SUBJECT: Engineering Review Comment
Mountain View Electric Association Inc. (MVEA)

Project Name: Homestead at Sterling Ranch Filing 3

Project Number: VR234

Description: Proposed vacation and replat of Tract D in Sterling Ranch Filing 1 and Lots 24-27 and Tract B in Homestead at Sterling Ranch Filing 2 located east of Vollmer Rd. and south of Briargate Pkwy. in Township 12S, Range 65W, Section 33.

# HOMESTEAD AT STERLING RANCH FILING NO. 3

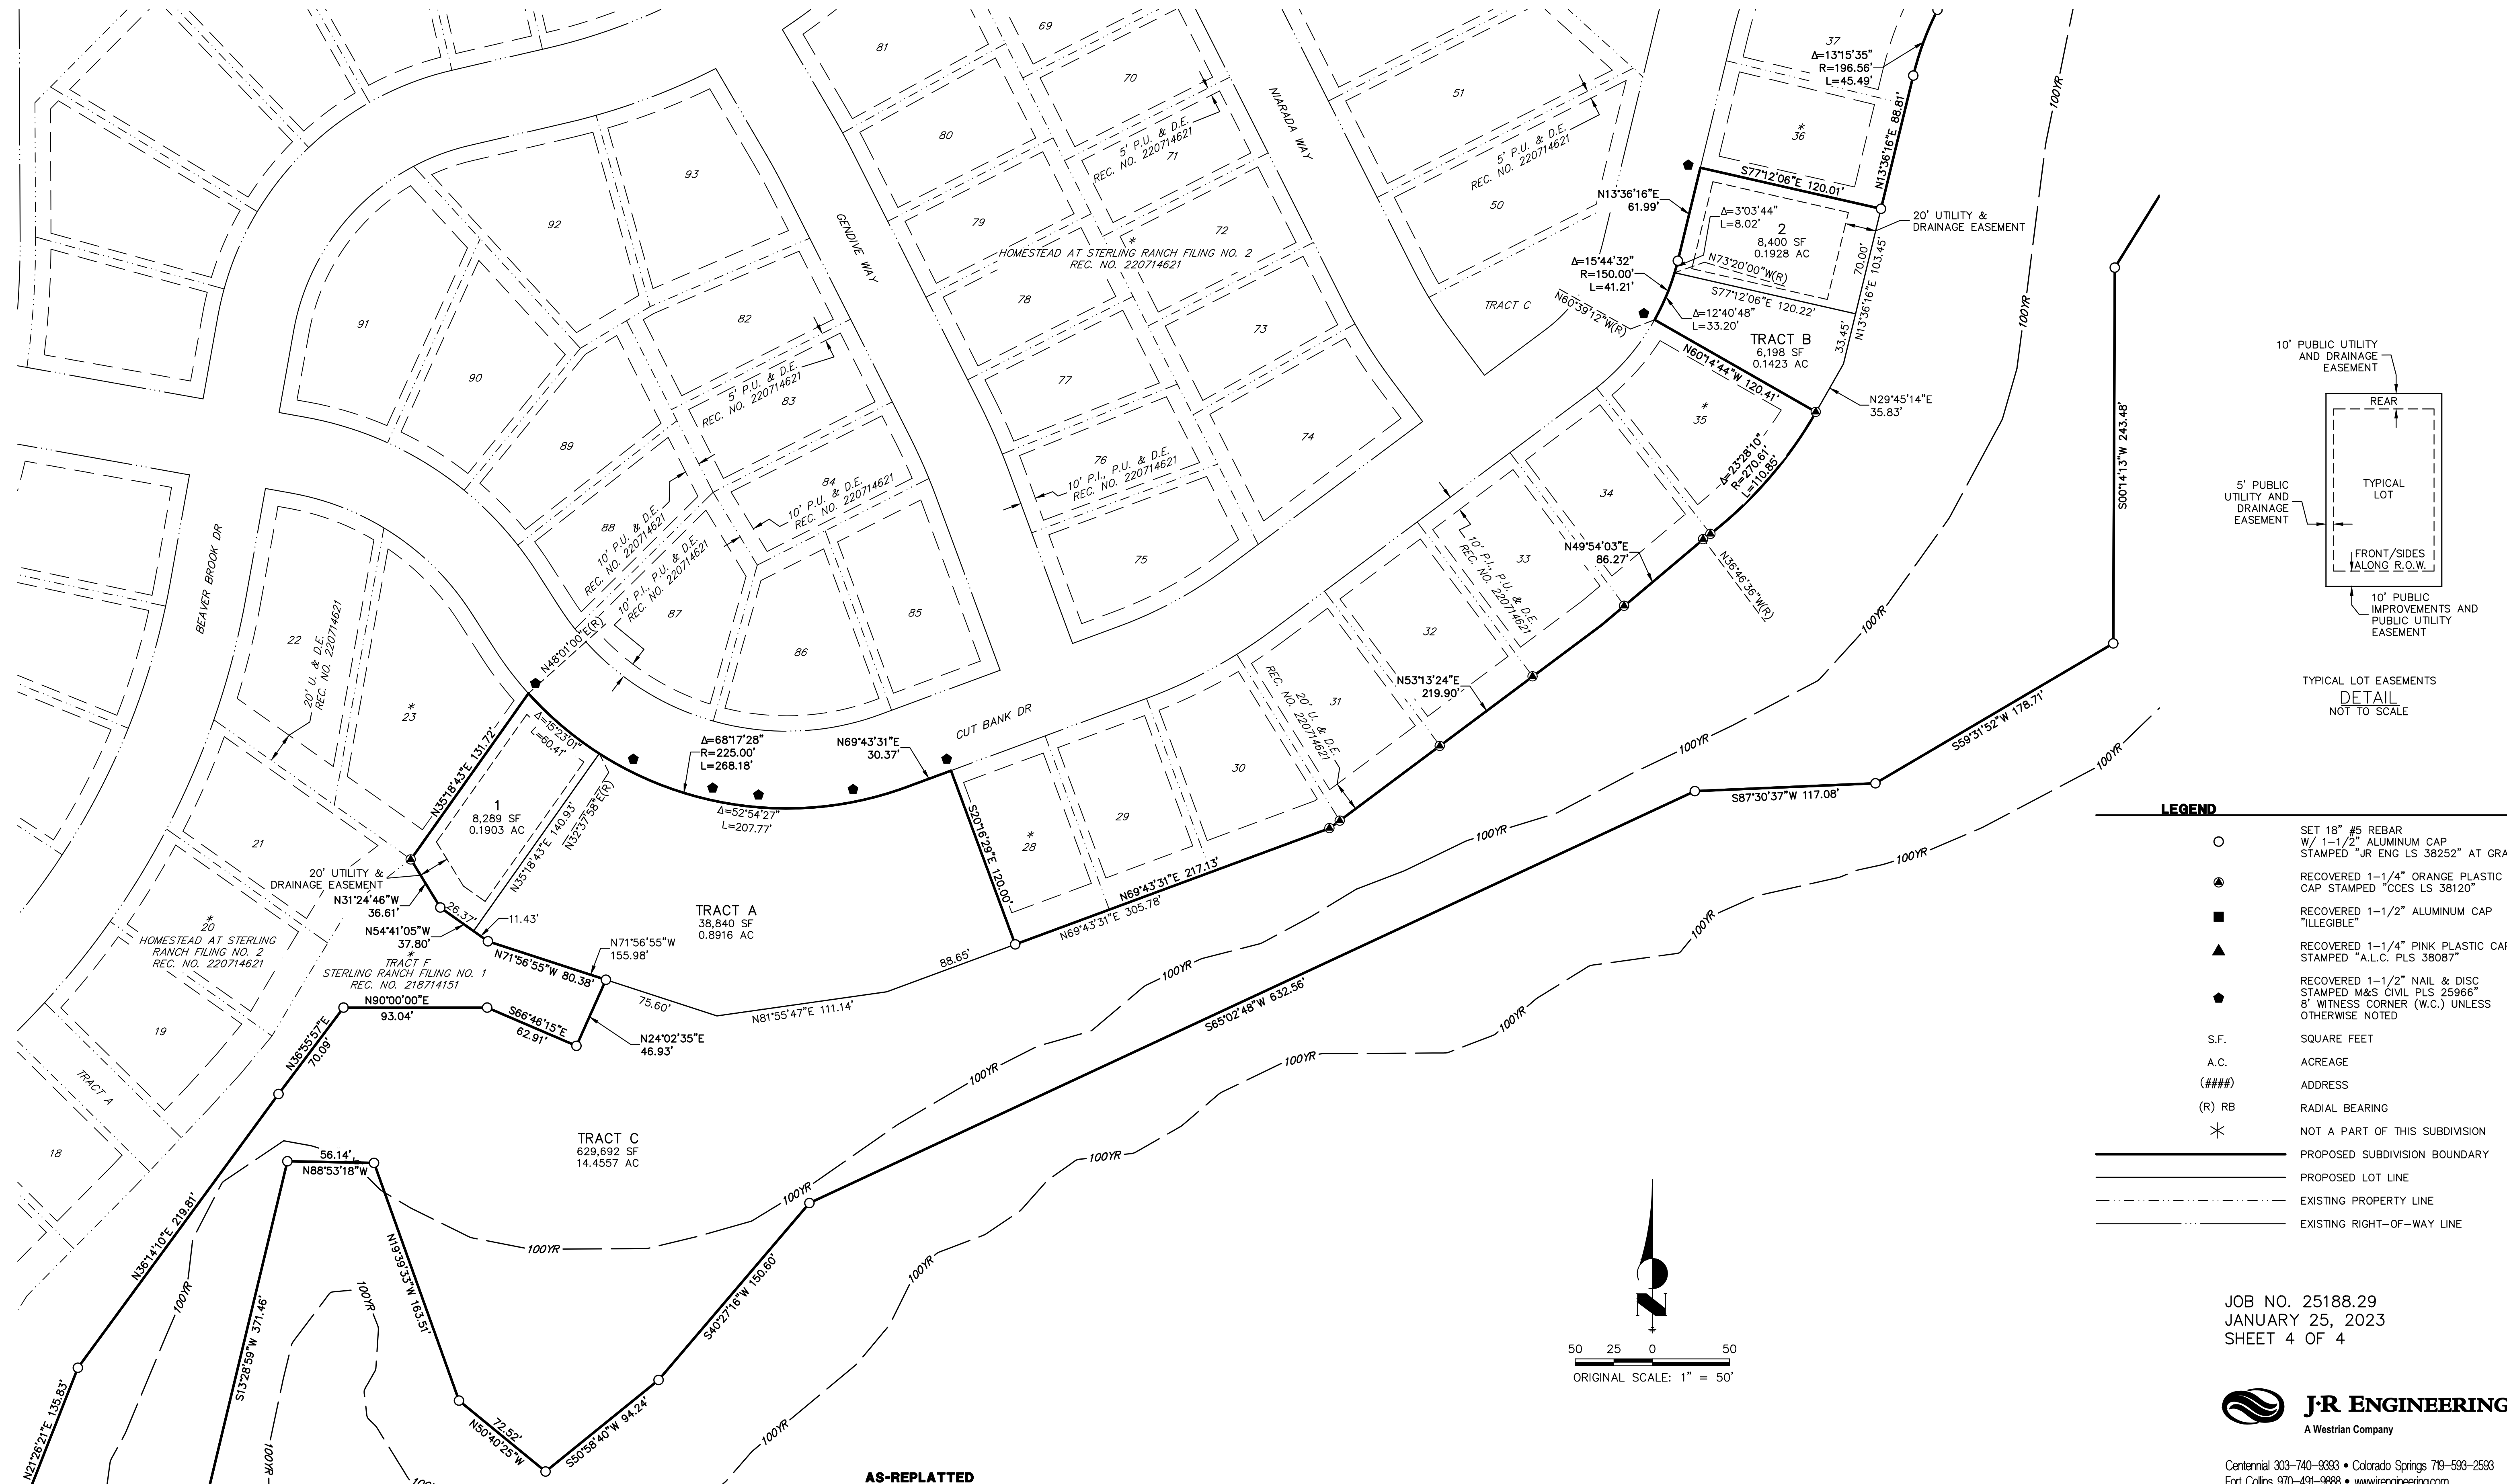
MVEA requests a ten (10) foot front lot utility easement in addition to any public improvement easement, a five (5) foot side lot utility easement, and a ten (10) foot rear lot utility easement along with a twenty (20) foot exterior utility easement on the plat and all tracts include easements. MVEA also requests the platting of MVEA's existing facilities with easements on the plat. Additional easements may be required.
